# Port Kembla Gas Terminal Submissions Report

February 2019

Australian Industrial Energy  
Port Kembla Gas Terminal

## SUMMER THERMAL PLUME

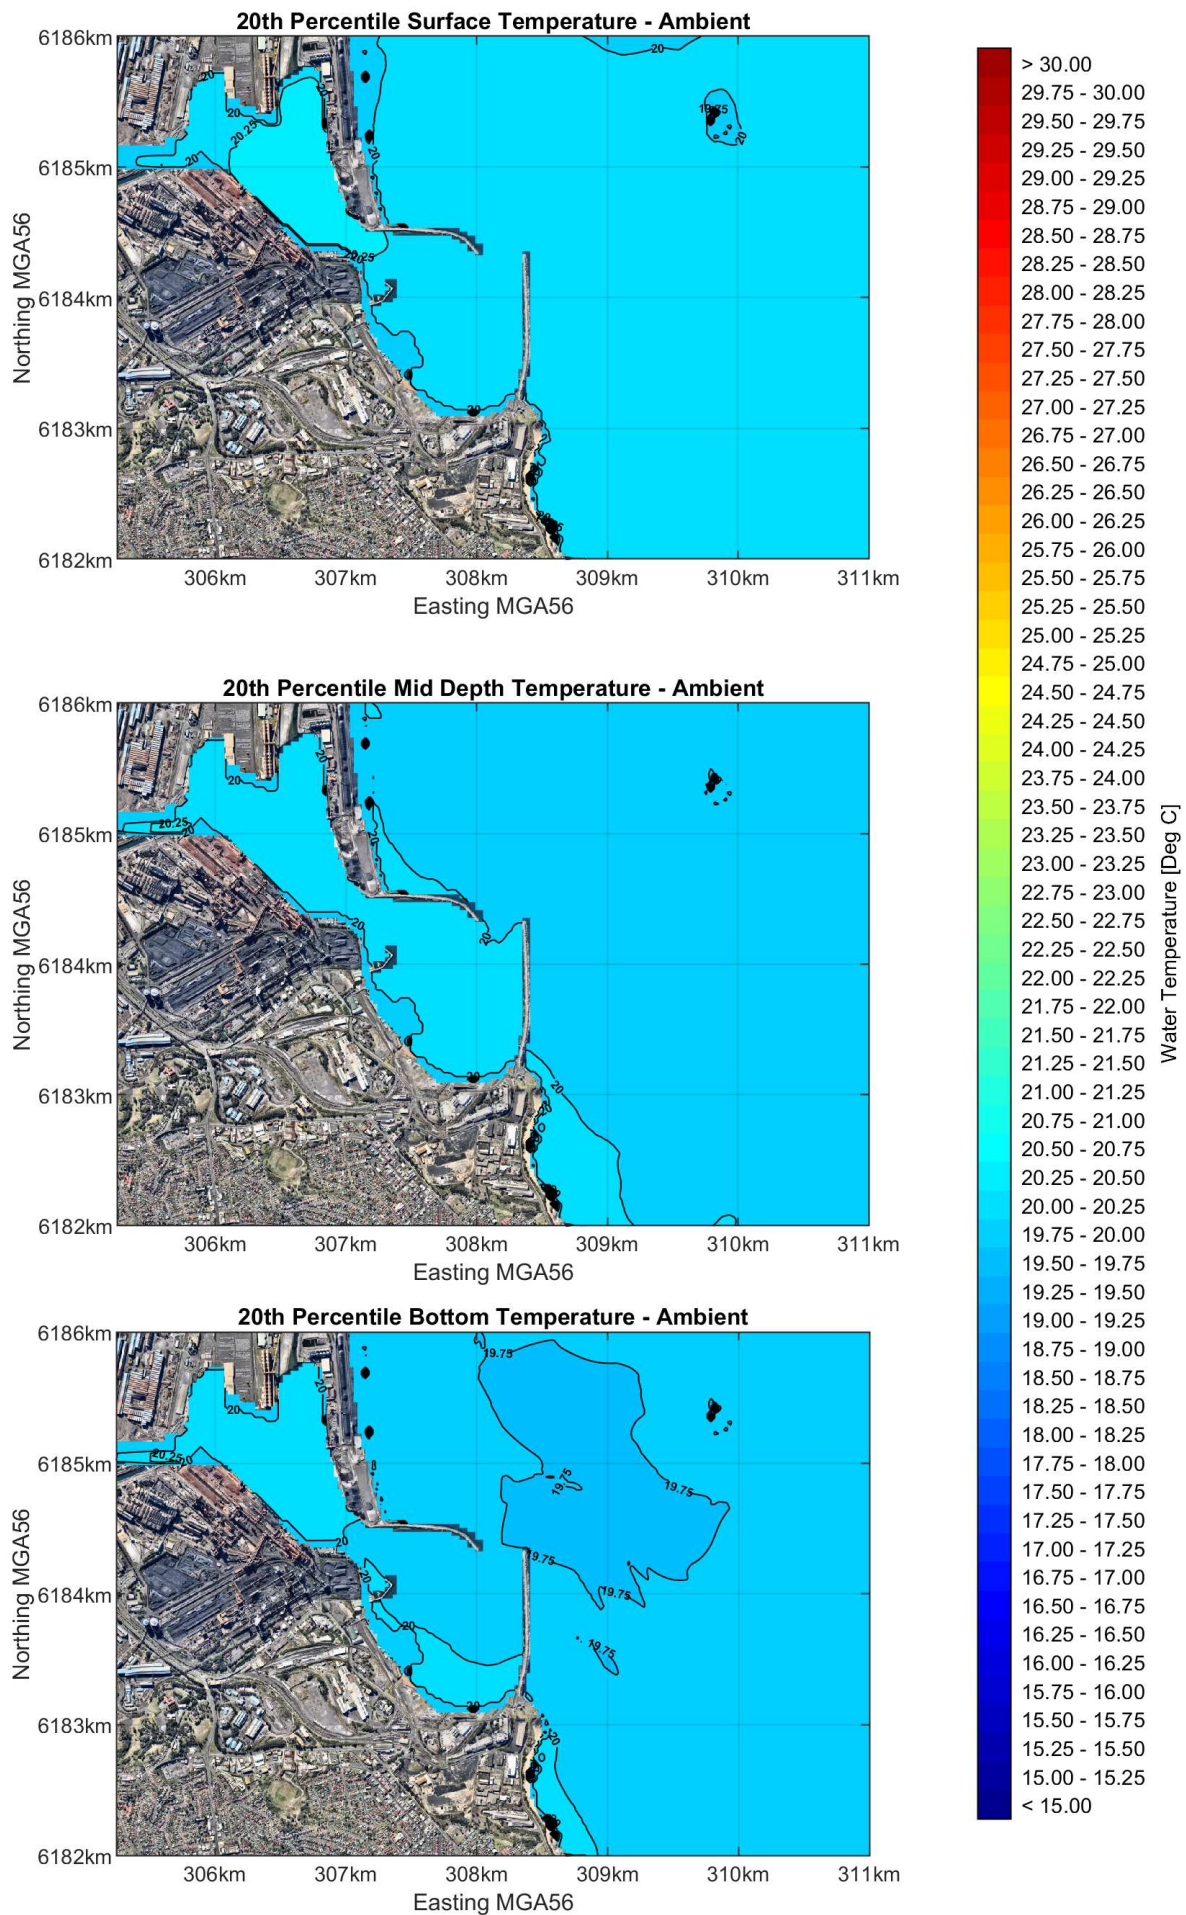
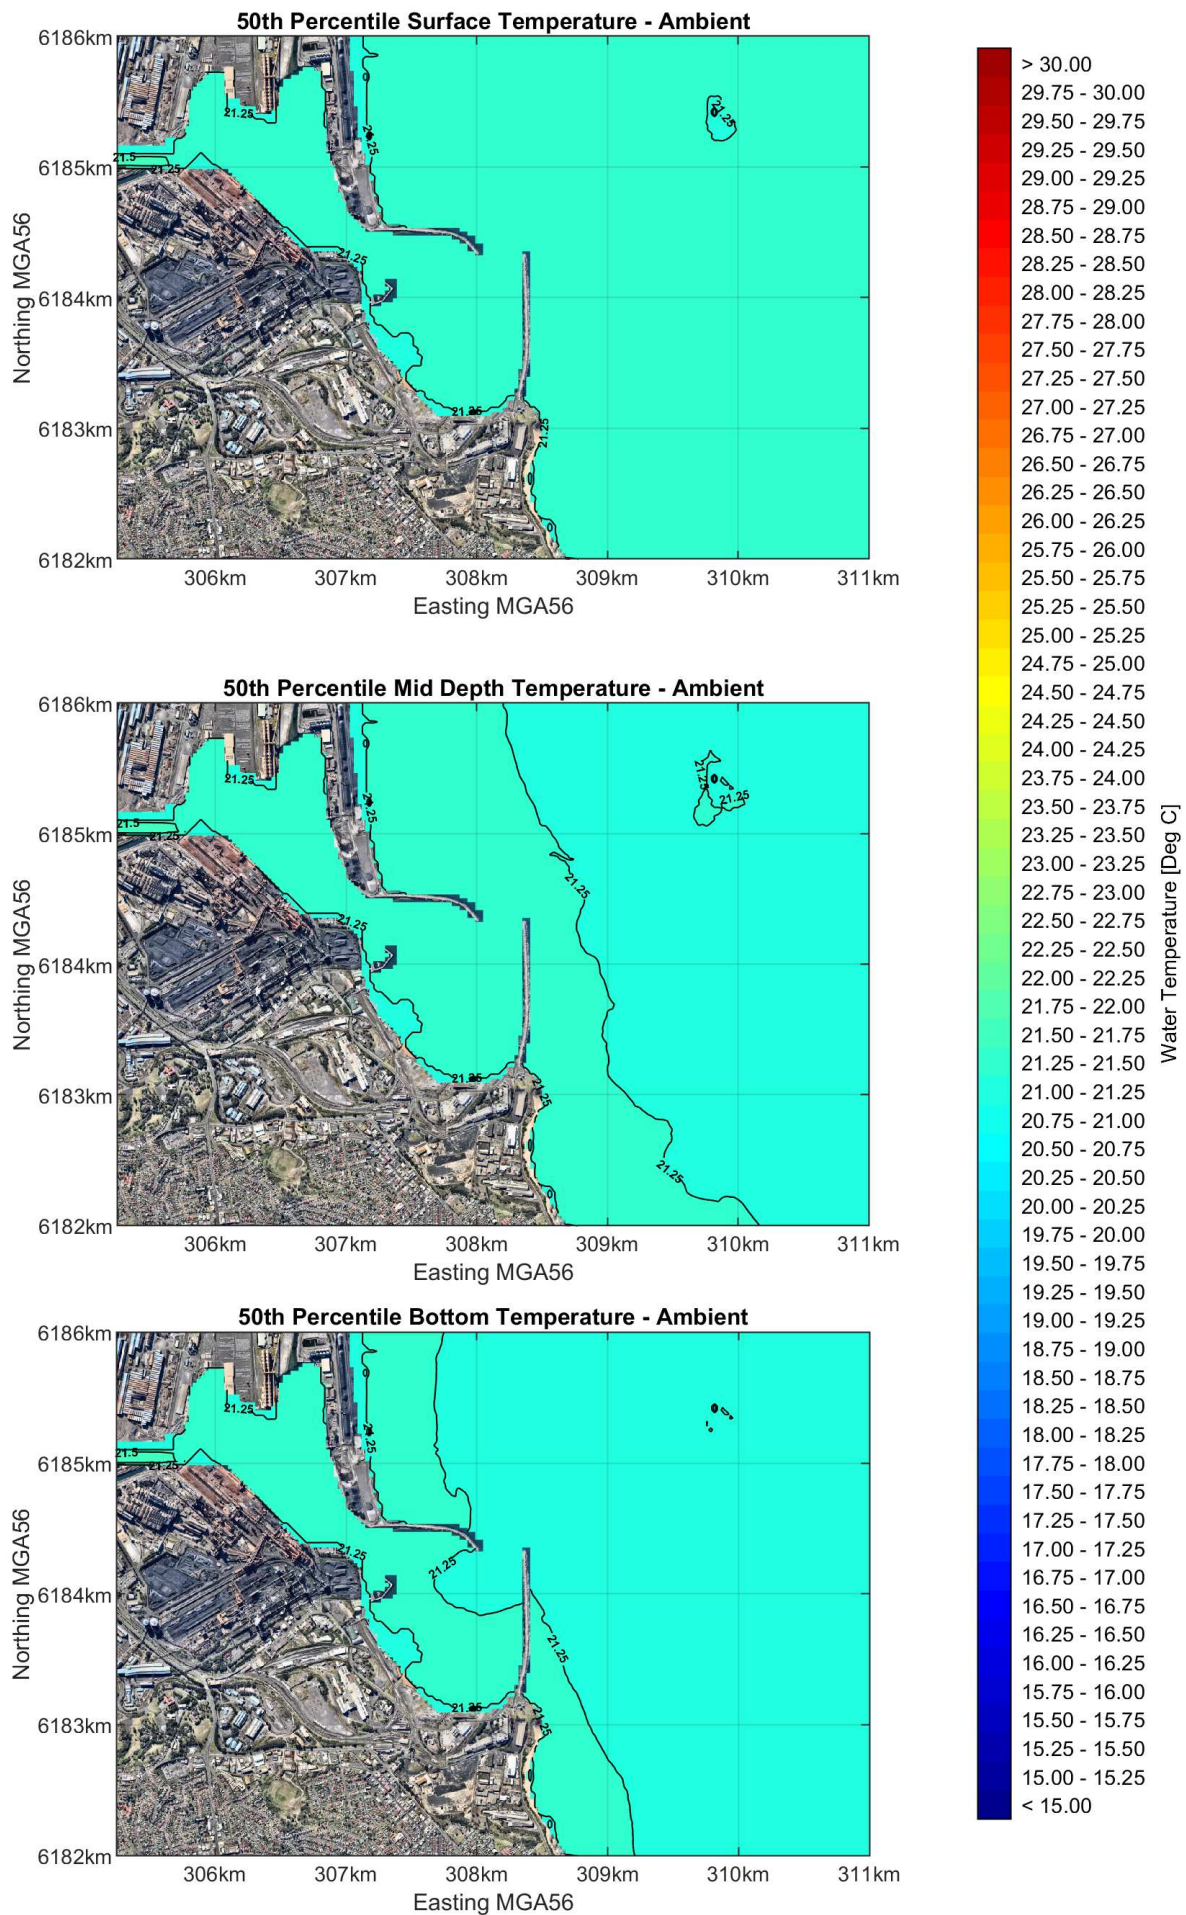
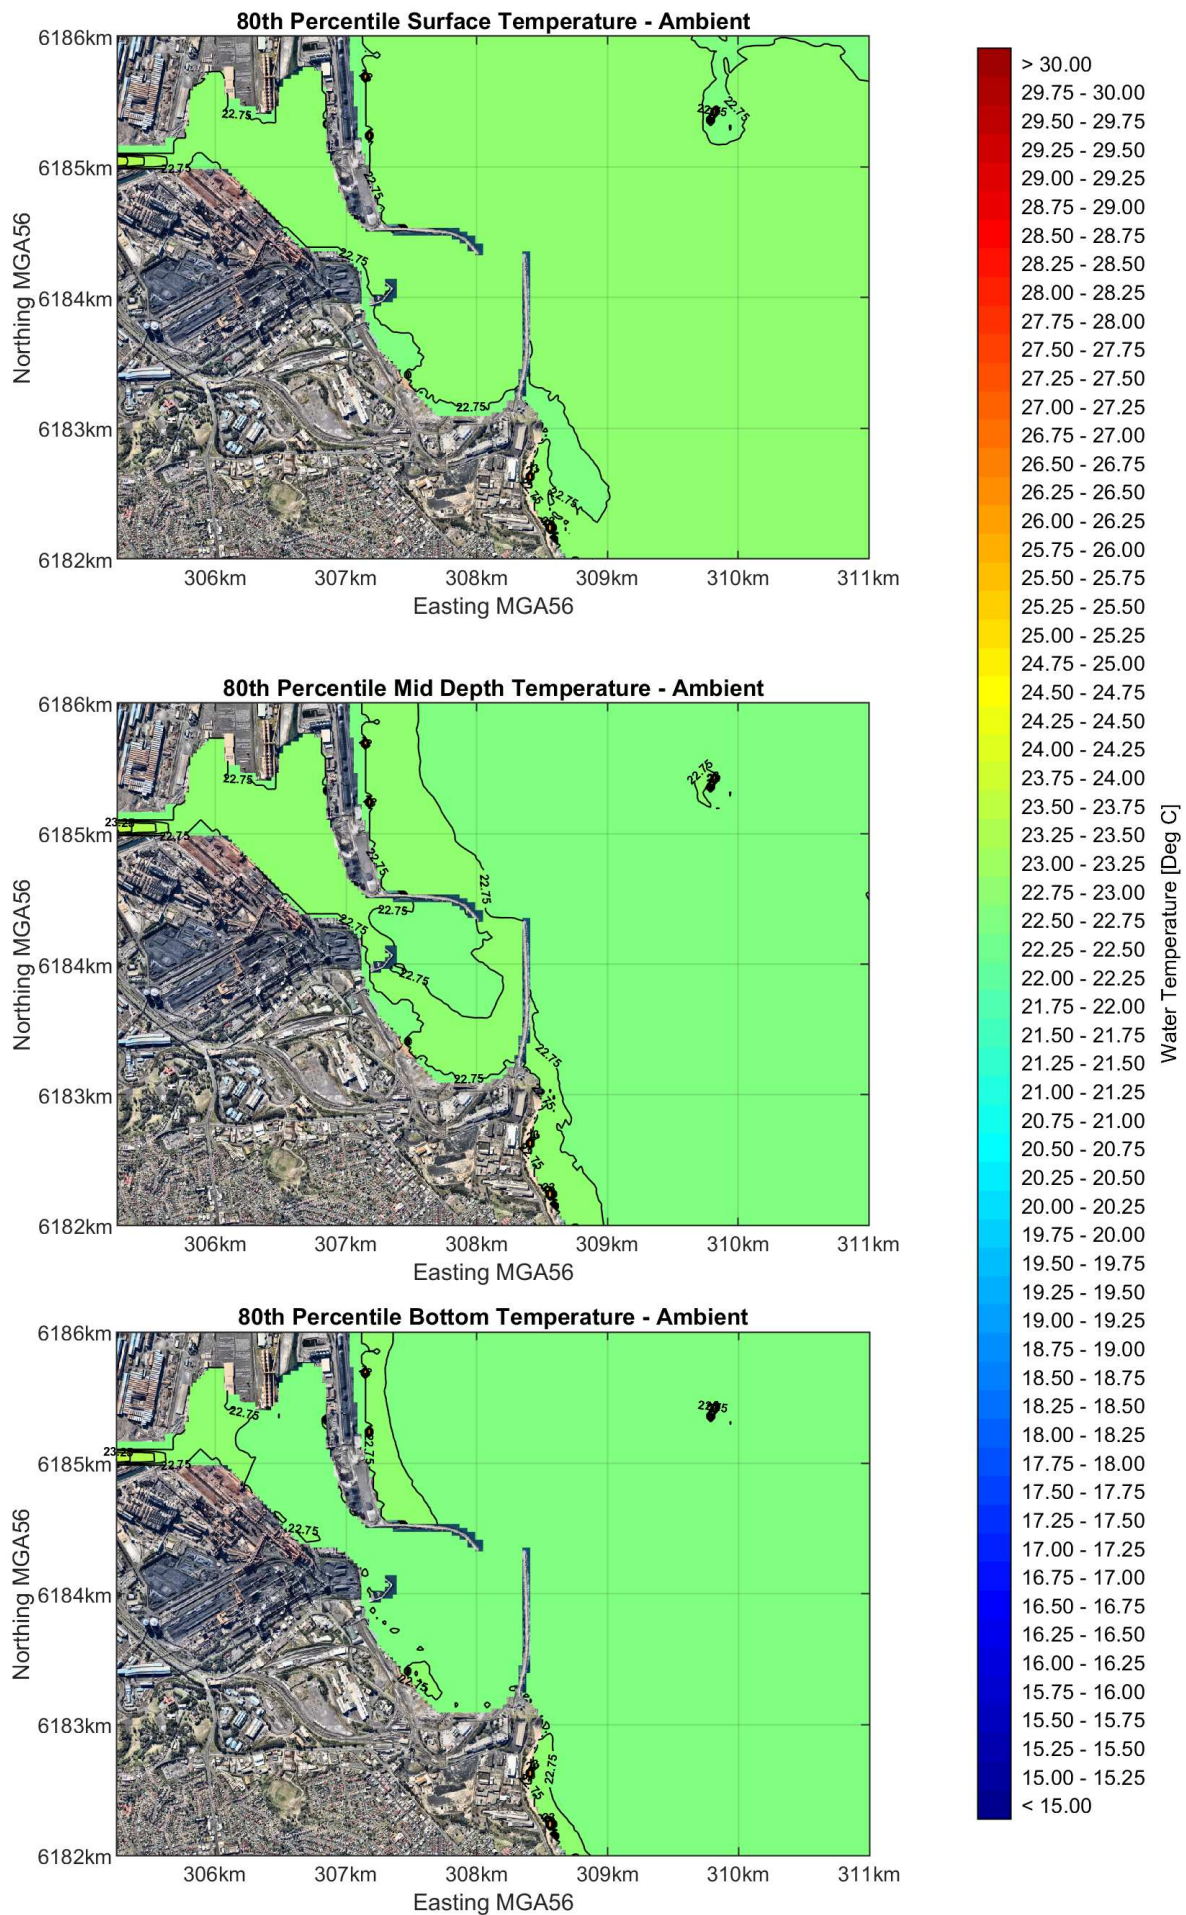
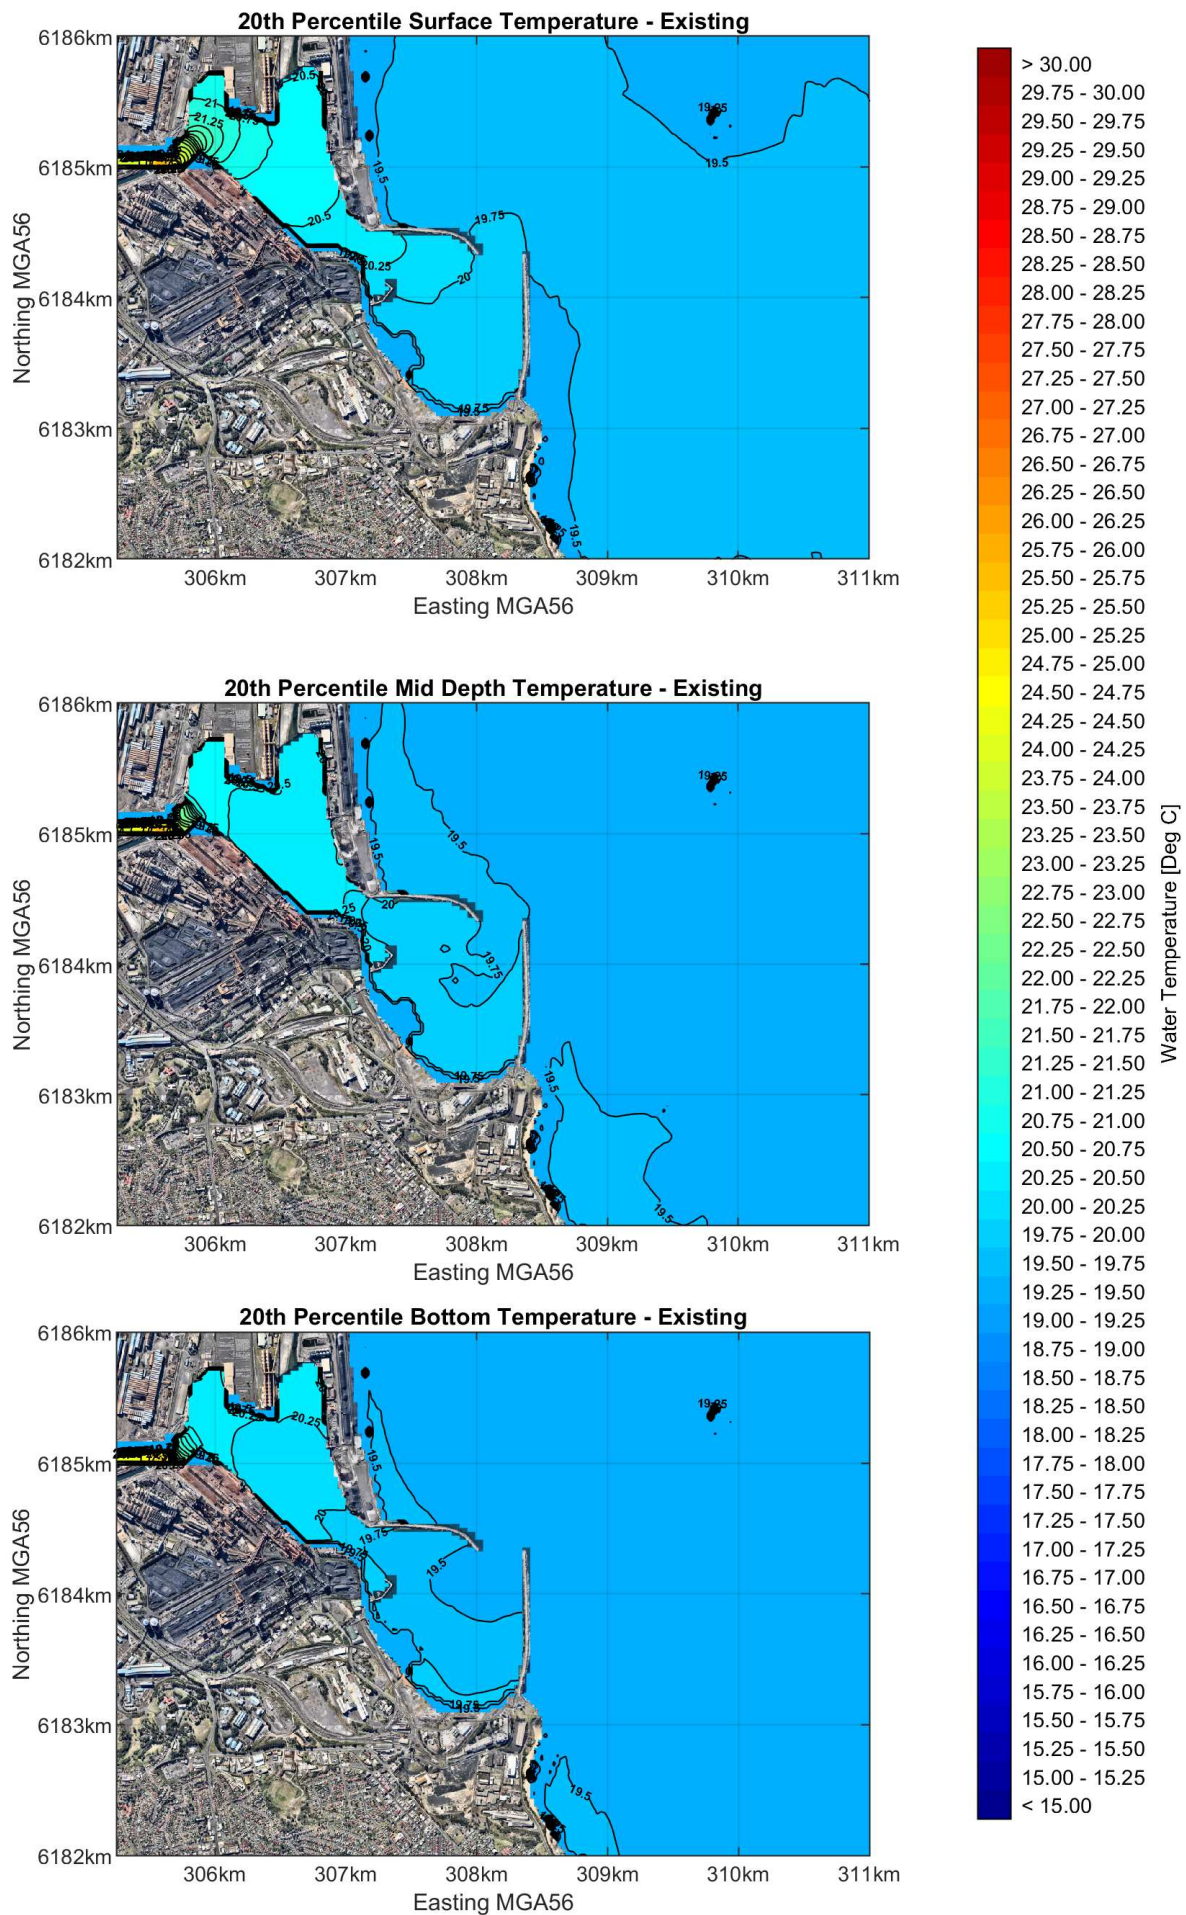
<p><b>Thermal plume charts</b></p> <p>The submission made reference to the thermal plume charts presented in the EIS. It stated the resolution of the charts was limited. It noted the minimum temperature was expressed as “less than 16.5°C” and stated a full range of temperatures including minimums should be presented.</p>	Section 4.2.2
	<p><b>Alternative management measures</b></p> <p>The submission recommended additional measures be considered if there are acute impacts in the mixing zone or water quality objectives are not met at the edge of the near field mixing zone.</p>	Section 4.2.2
